CITY OF ALBUQUERQUE

February 6, 2018

**Re: Floor and Decor
Erosion and Sediment Control Plan
Engineer's Stamp Date 1-26-18 (F17E032)**

MCLEOD & I-25 FRONTAGE IMPROVEMENTS

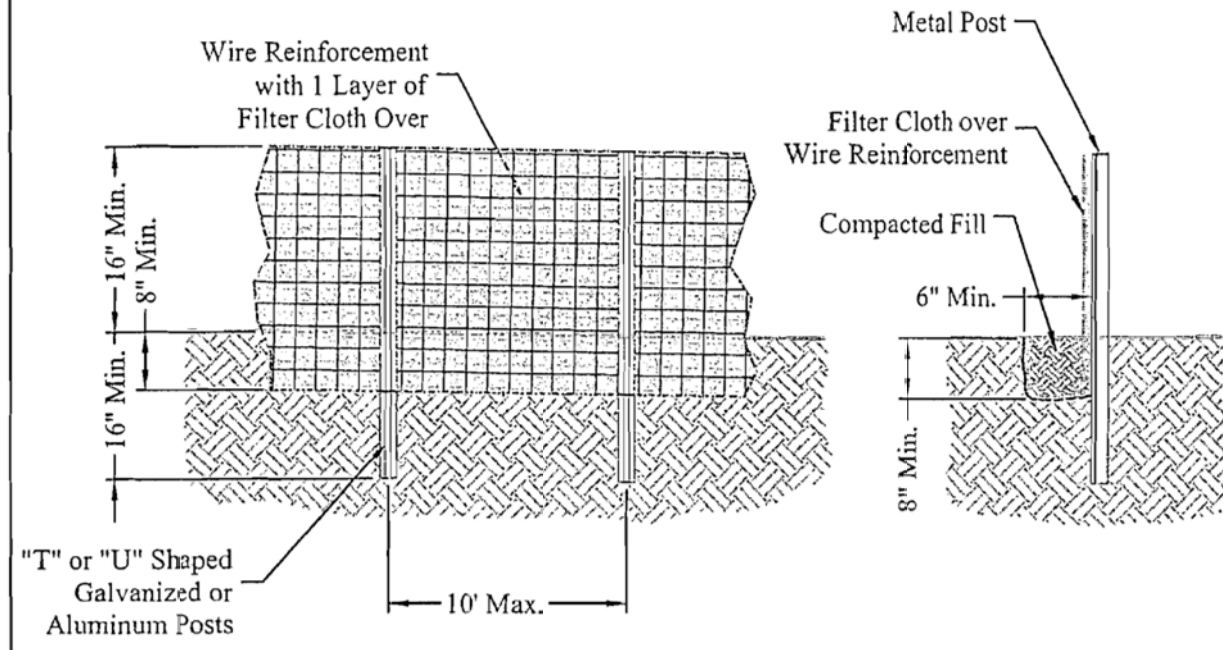
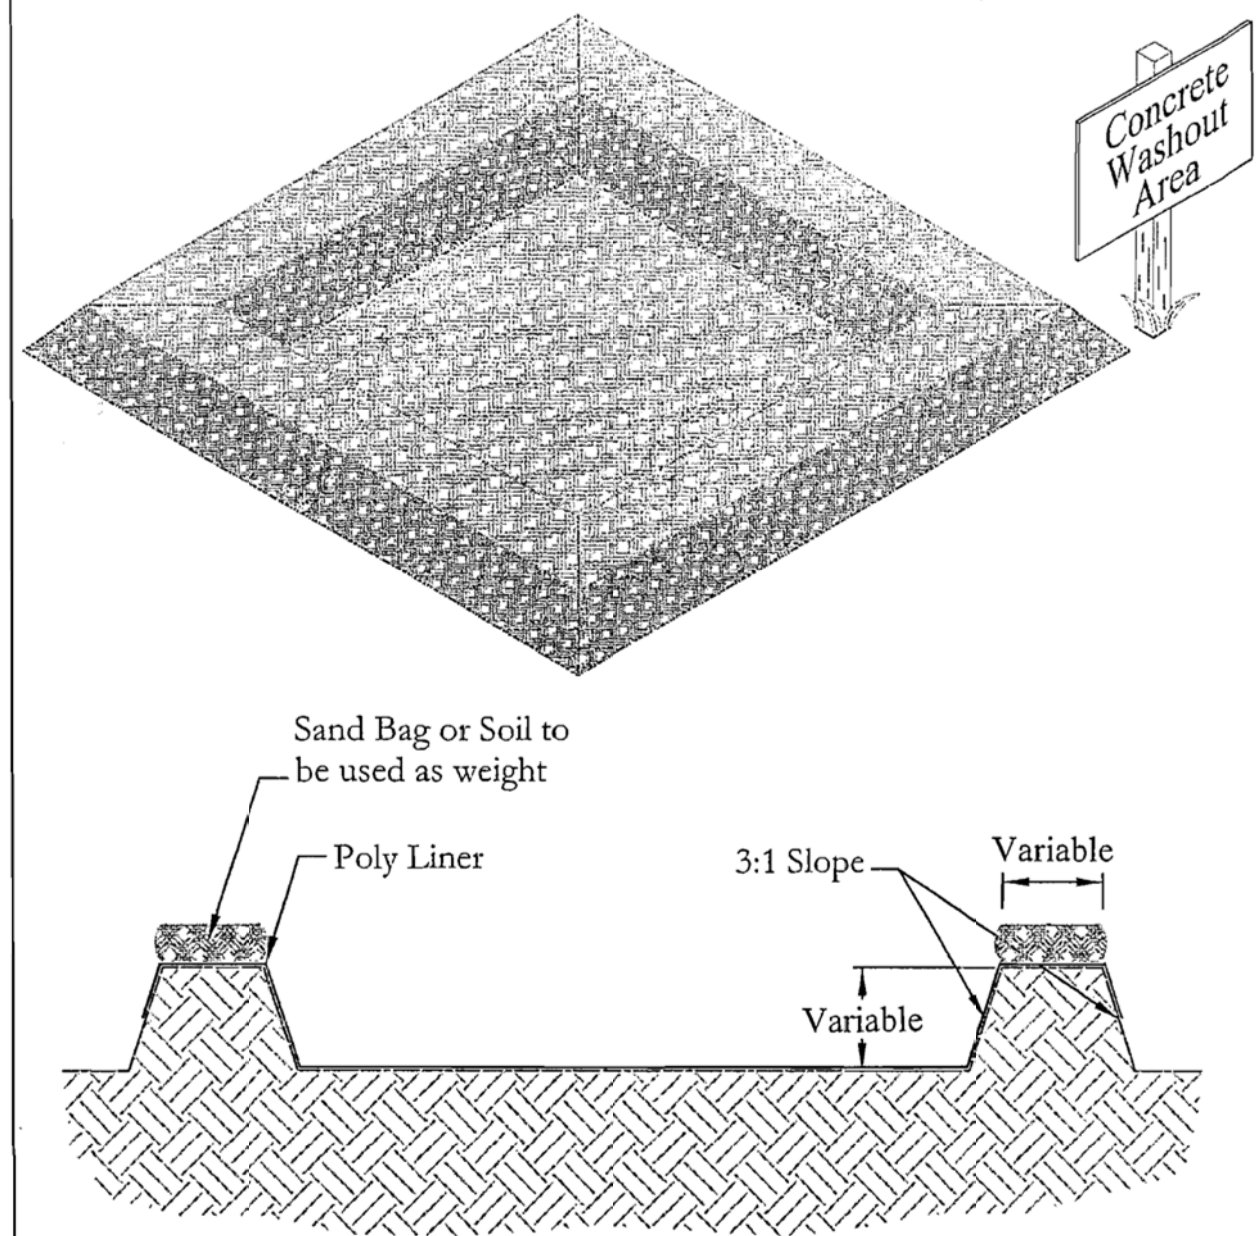
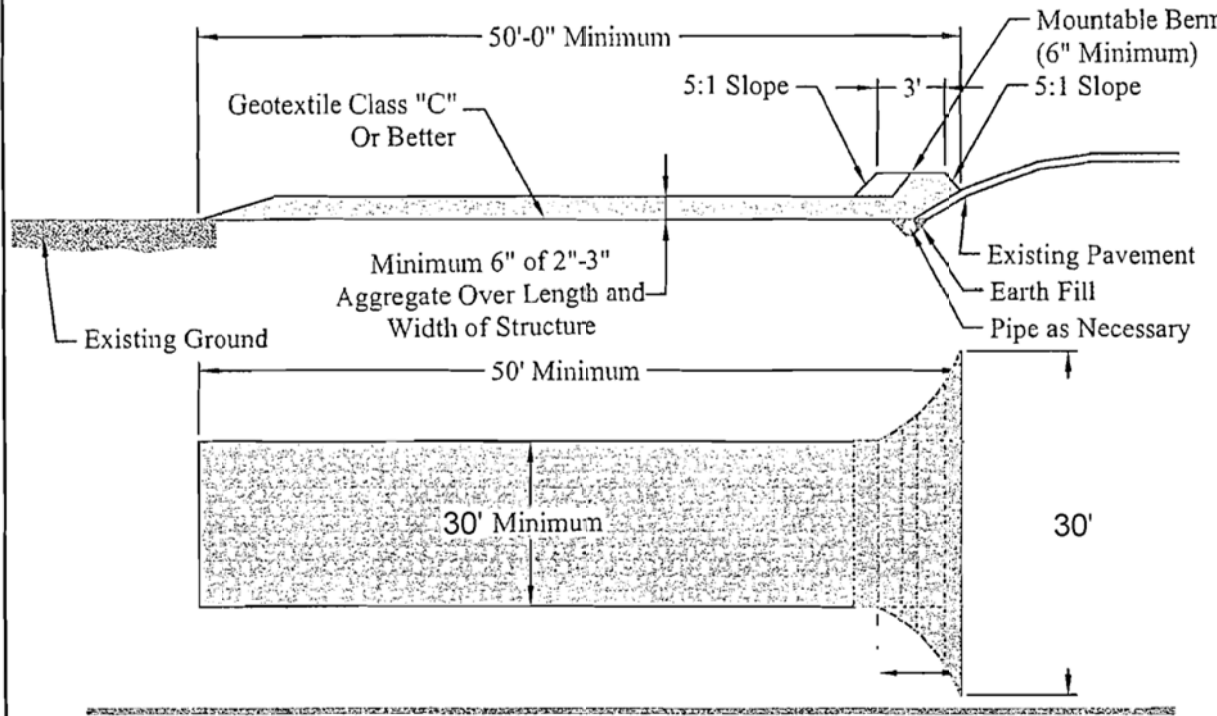
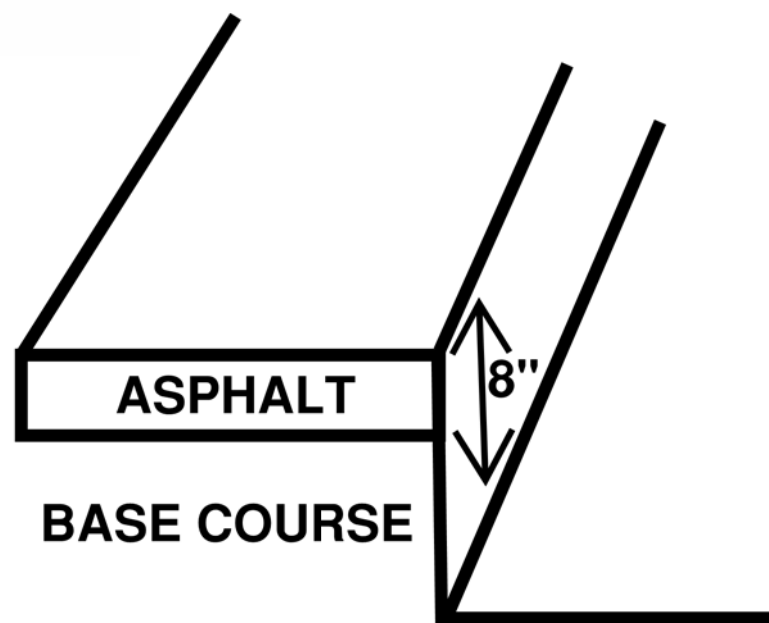
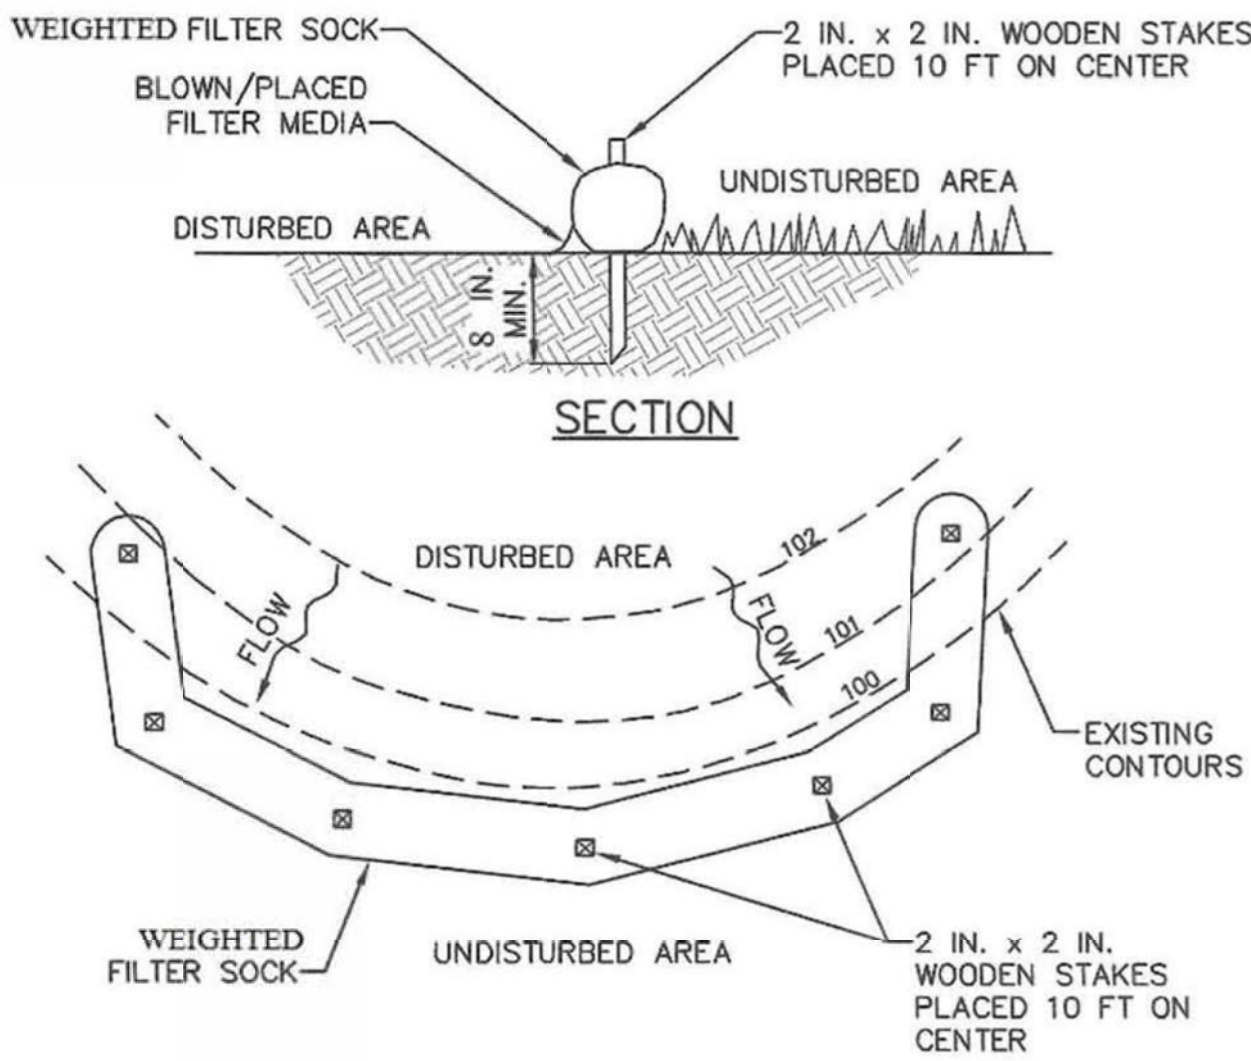
1. After discussion with the NMDOT, a sediment BMP should be proposed between the deceleration lane(s) and the swale on Pan American Frwy to prevent sediment from entering the swale area.
2. Please revise the note concerning self-inspections and include language for the required reports.
